SPR EA1N and EA2 PROJECTS

DEADLINE 5 - COMMENTS ON APPLICANTS DEADLINE 4 SUBMISSIONS

Interested Party: SASES PINS Refs: 20024106 & 20024110

Date: 3 February 2021

Plate 3.1: HVAC 190x190m substation model for 800MW

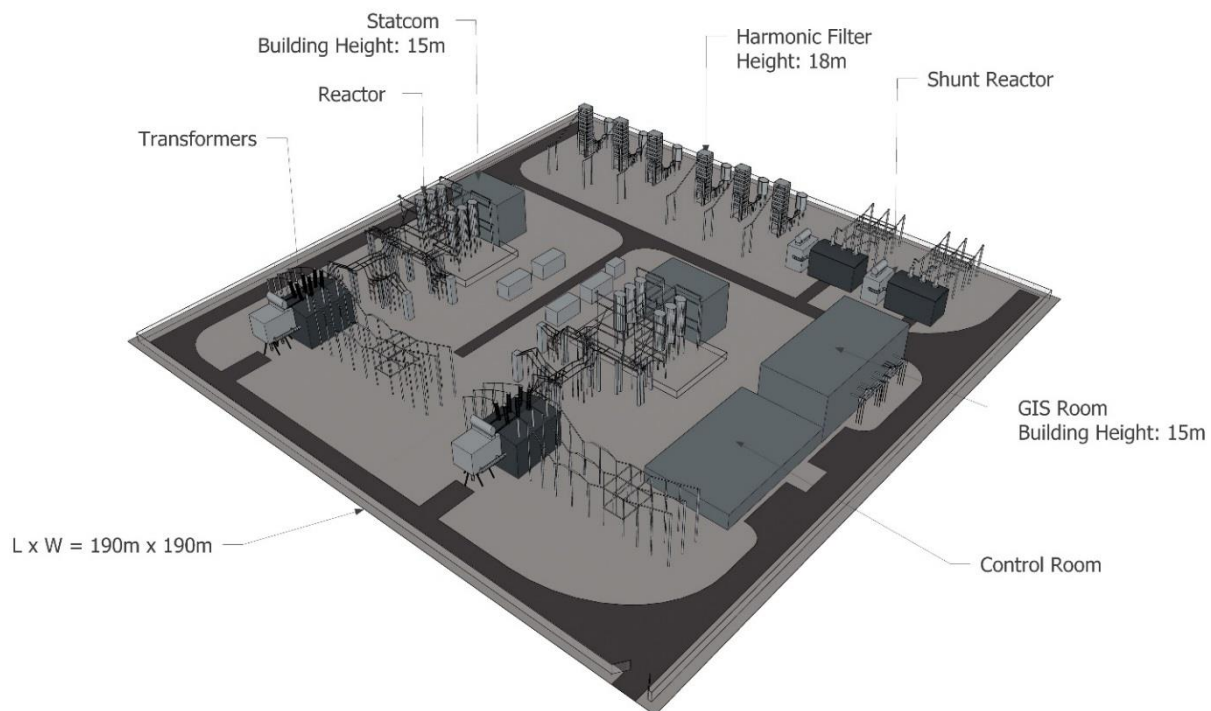
5. SASES does not accept that 170m x 190m (**3.23ha**) is the smallest substation footprint that can be achieved and refers the Applicant to its Deadline 4 representations [[REP4-104](#)] which cross-refer to a **2.1ha** benchmark footprint for an 800MW HVAC substation as advised by NGESO in their report for the BEIS OTNR. Also a comparator may be made to the **3.22ha** footprint of the 1200MW Hornsea One HVAC substation which is 50% more powerful than the proposed EA1N substation and yet has a smaller footprint. The current SPR proposal cannot be optimum on this basis.
6. Further, SASES notes that the current proposals reserve some **7ha** of land for use by the initial or expanded NGET substation, when the Application makes no justification for the

7. It may further be noted that a project comprising two 2.1ha wind farm substations (NGESO metric) and the GIS version of NGET substation (1.7ha) would require no more than half the land currently reserved in Application for substation construction. How in that case can the current application be described as '*space efficient*' (para 28 line 2)?
